High Plains, SF-18-024

Please accept the following comments from El Paso County Public Health (EPCPH) regarding the 39.4 acre, 7 residential lot development project referenced above:

**Mike McCarthy, R.E.H.S.
El Paso County Public Health
mikemccarthy@elpasoco.com
719-575-8602
06Feb2019**

FINAL PLAT  
HIGH PLAINS FILING NO. 1  
A PORTION OF THE SOUTHWEST QUARTER OF THE SOUTHEAST QUARTER OF SECTION 19, TOWNSHIP 11 SOUTH, RANGE 65 WEST OF THE 6TH P.M. COUNTY OF EL PASO, STATE OF COLORADO

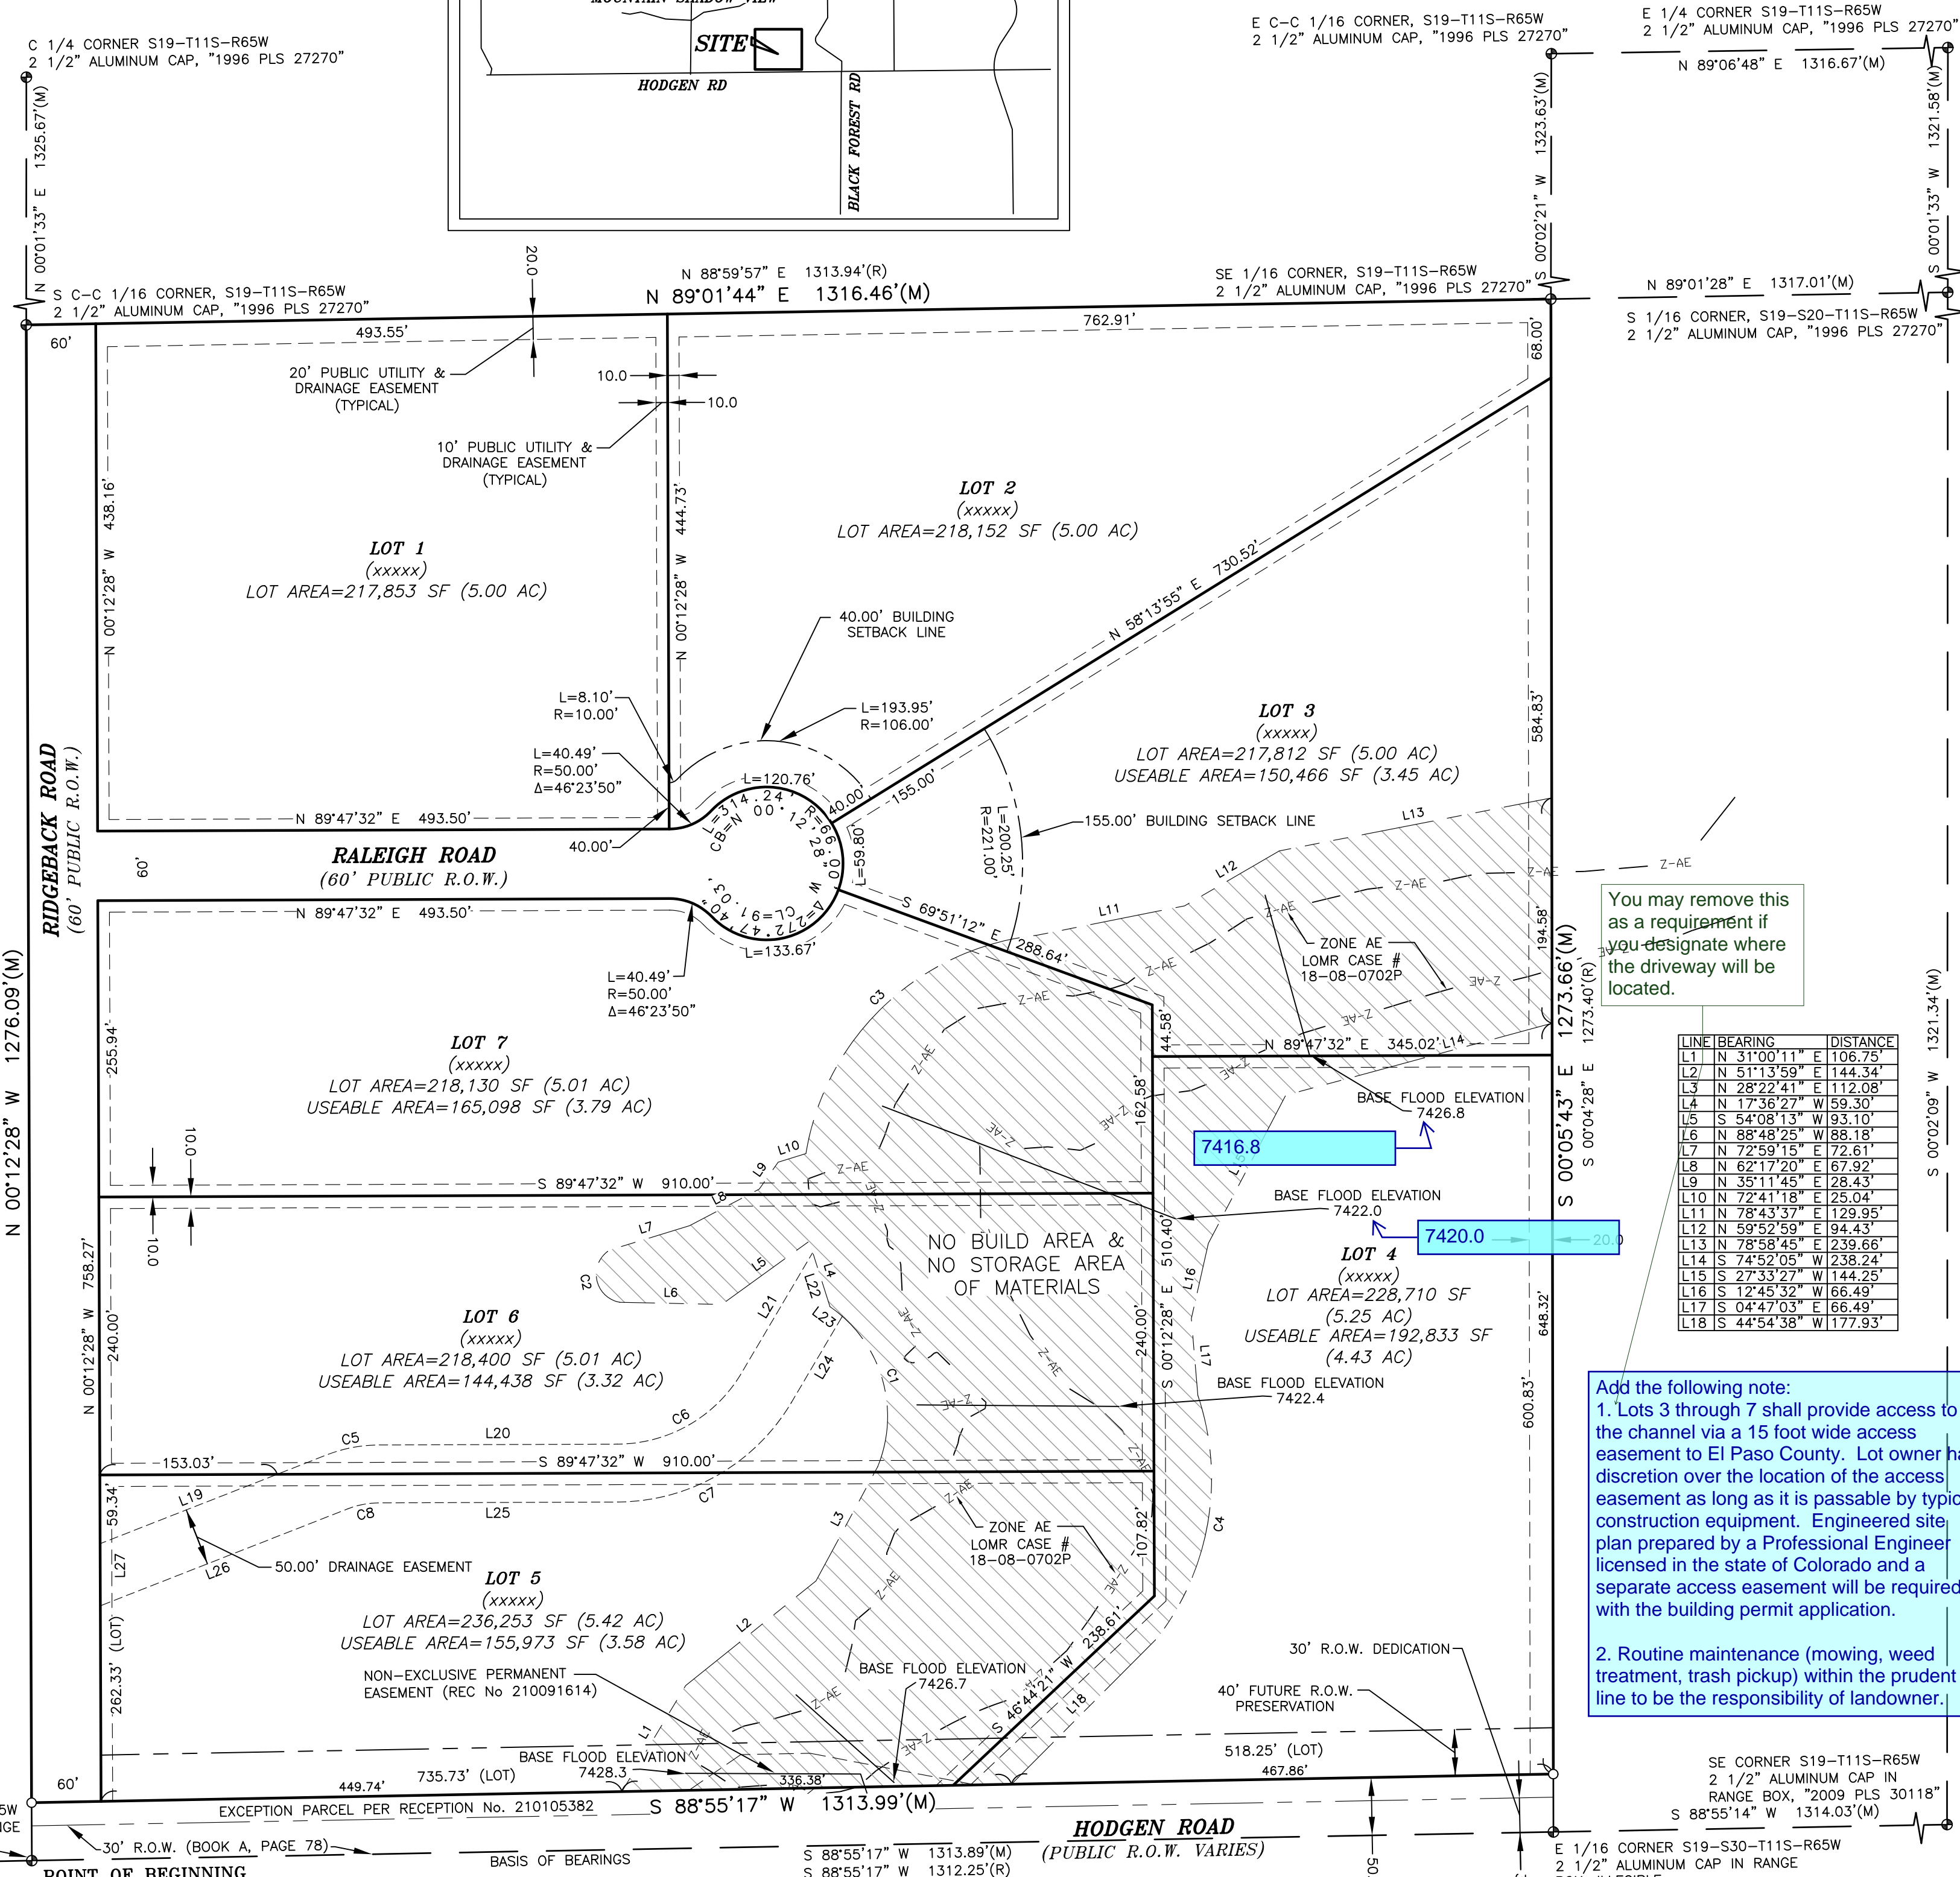
- Careful planning is required when locating a private well and onsite wastewater treatment system (OWTS) on lots 3 and 6 due to identified areas of potential seasonal shallow groundwater identified in the Entech Engineering, Inc., Soil, Geology, Geologic Hazard, and Wastewater Study Report.
